The Planning Act 2008

Section 55 Acceptance of Applications

Section 55 Application Checklist¹

Section 55(2) Acceptance of Applications				
1	Within 28 days (starting day after receipt) the Secretary of State must decide whether or not to accept the application.	Date received	28 day due date	Date of decision
		27 June 2018	25 July 2018	23 July 2018
Section 55(3) – the Secretary of State may <u>only</u> accept an application if the Secretary of State concludes that:-		Planning Inspectorate Comments		
s55(3)(a) and s55(3)(c) It is an application for an order granting development consent				
2	Is the development a nationally significant infrastructure project ² (NSIP) (or does it form part of an NSIP); and does the application state on the face of it that it is an application for a development consent order ³ (DCO) under the Planning Act 2008 (the PA2008), or equivalent words? Does the application specify the development to which it relates (i.e. which category or categories in ss14-30 does the application scheme fall)? If the development does not fall within the categories in	<p>Yes</p> <p>The proposed development set out in Schedule 1 of the draft DCO (dDCO) (Doc 3.1) is a Nationa

## Land Plan (Onshore) - Sheet 2

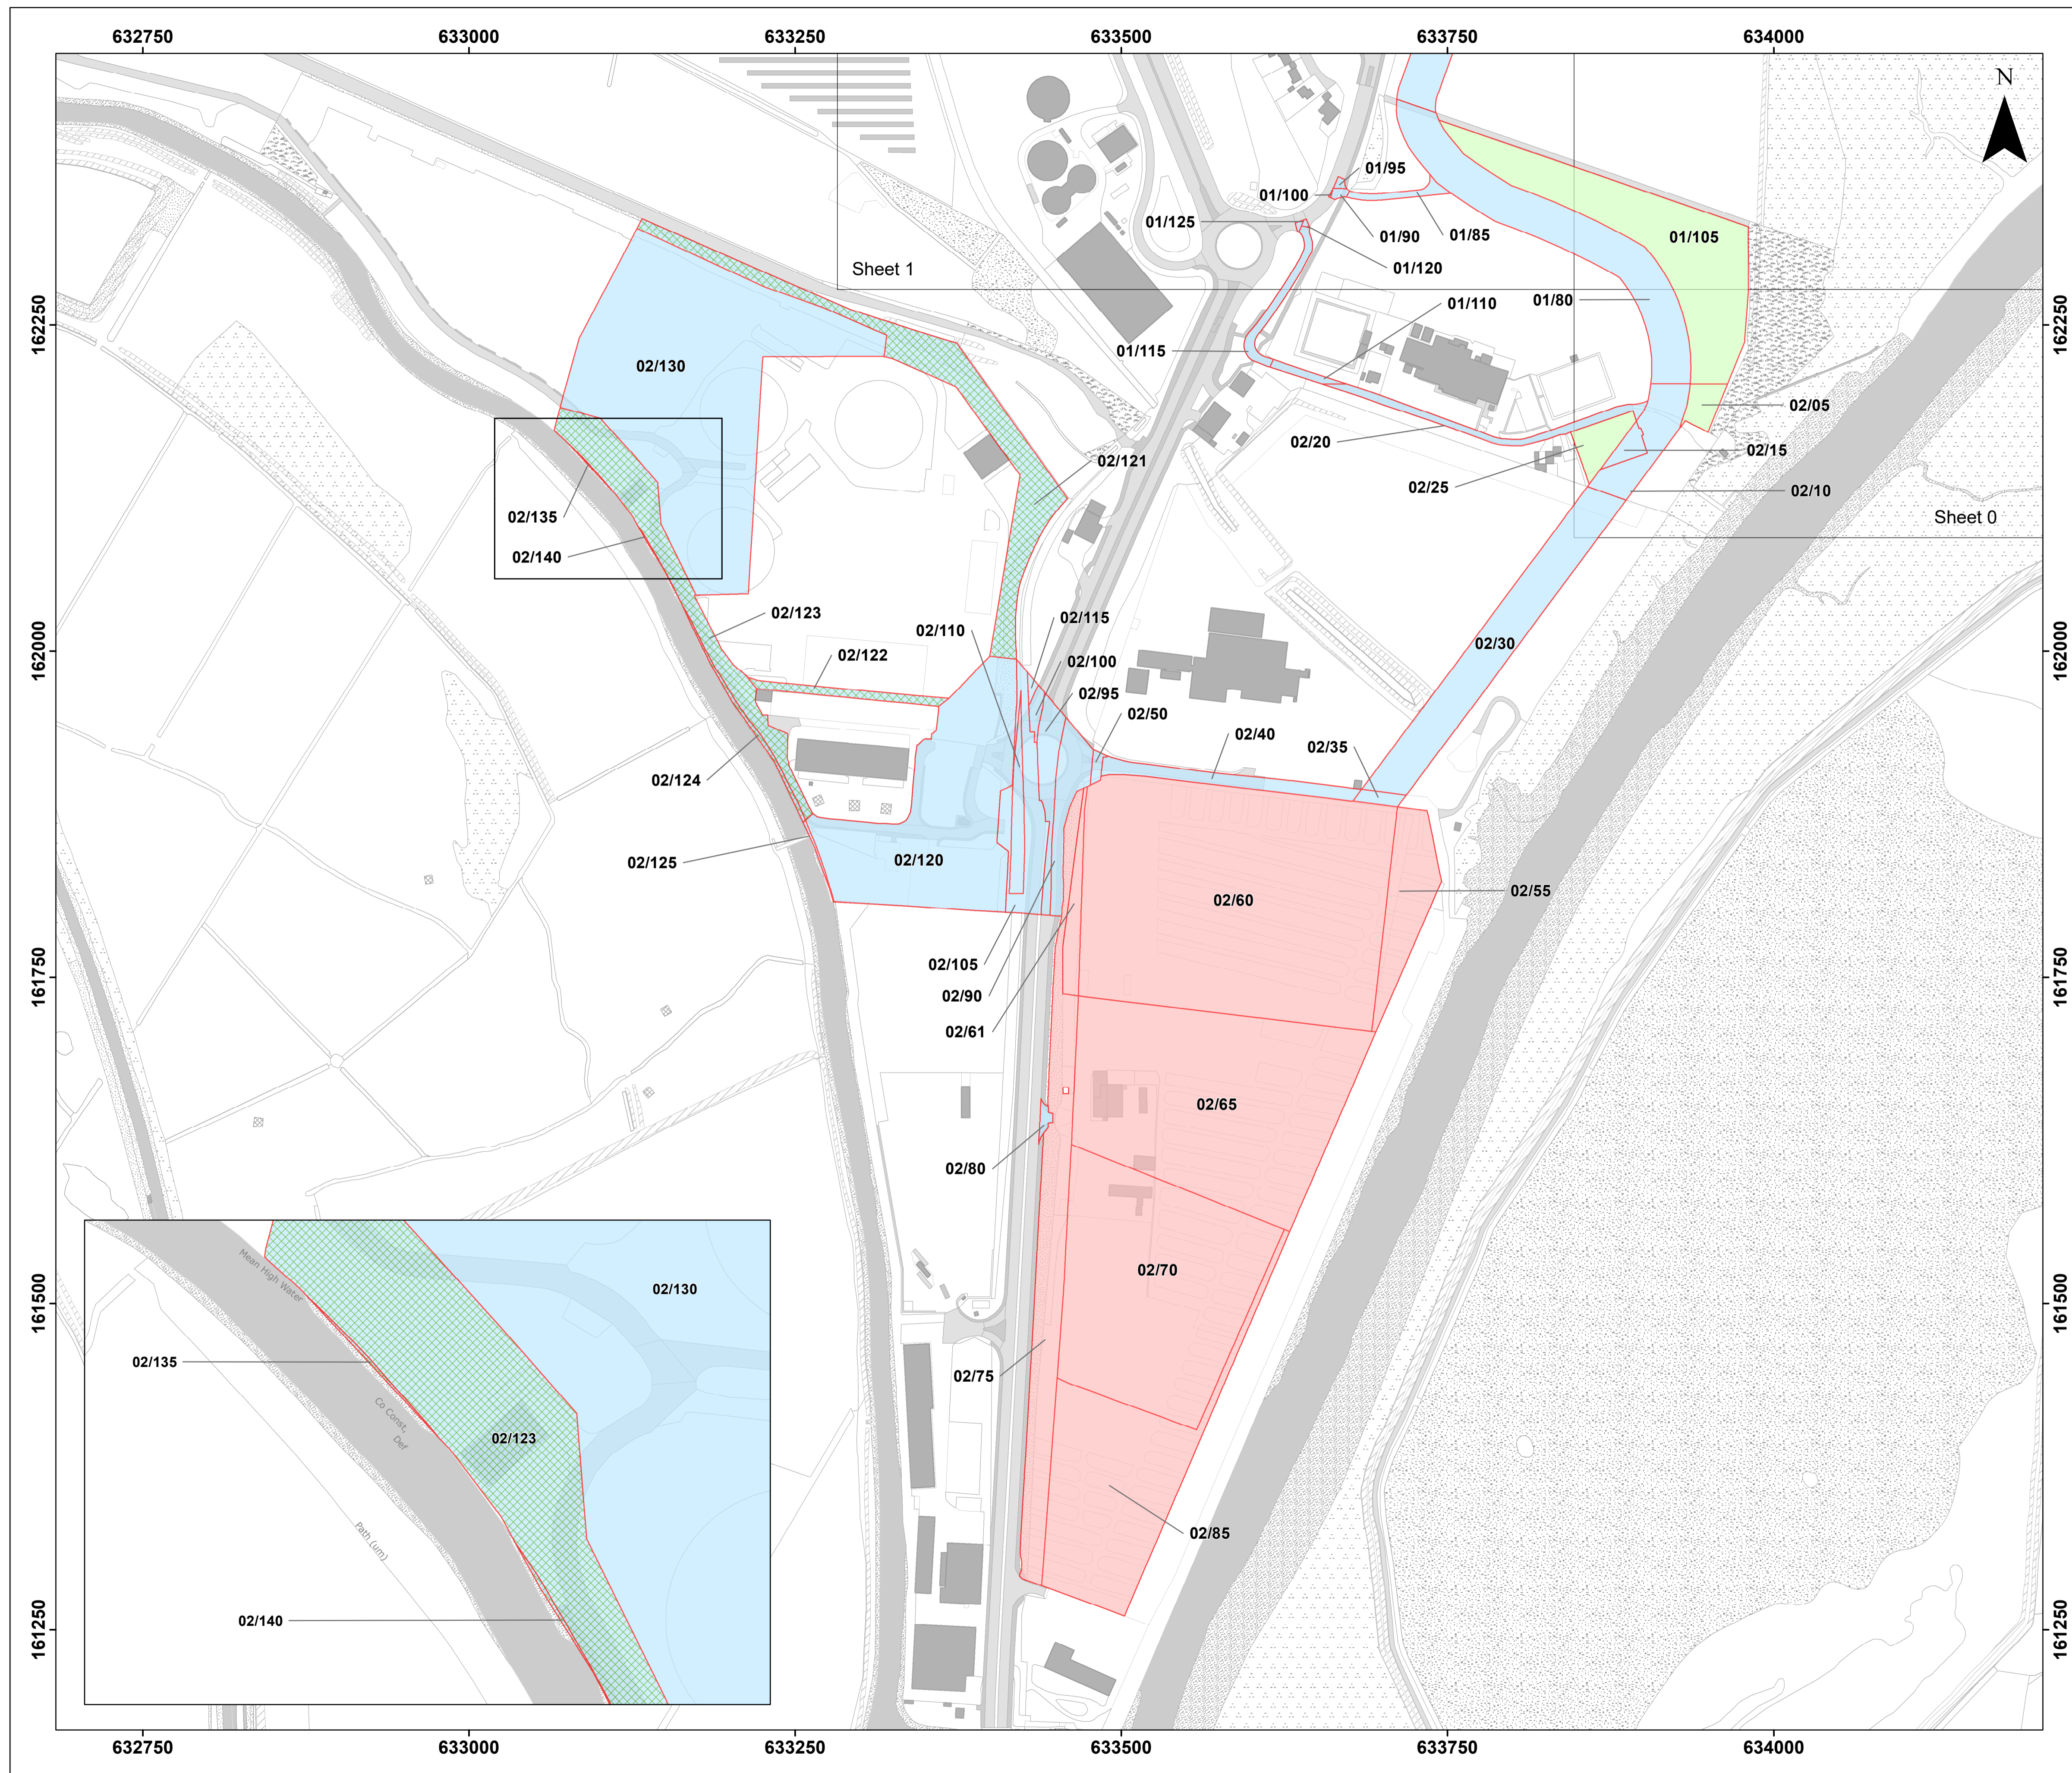
- Plot 01/110 is only identified on sheet 2 of the Land Plan Onshore. Should this plot be assigned an 02 reference?
- Plot 02/05 is coloured green on the land plan, showing it is temporary possession and is included in Schedule 7 of the DCO (Land of which Temporary Possession may be taken) and not in Schedule 5 (Land in which only New Rights etc., may be acquired). However the Book of Reference refers to new rights.

- Plot 02/85 is identified on the land plan as permanent acquisition but in the Book of Reference as new rights. This plot is not identified in the schedule 5 of the DCO (Land in which only New Rights etc., may be acquired).

- In the legend 'Cable route options' does not describe what rights are being sought.
- No landmarks or road names are identified on the land plans
- The scale is not in compliance with Regulation 5(4A) of the APFP Regulations, for the onshore plan sheet 0

[s51 advice](#) has been provided to the Applicant to remedy the issues raised in Box 30.
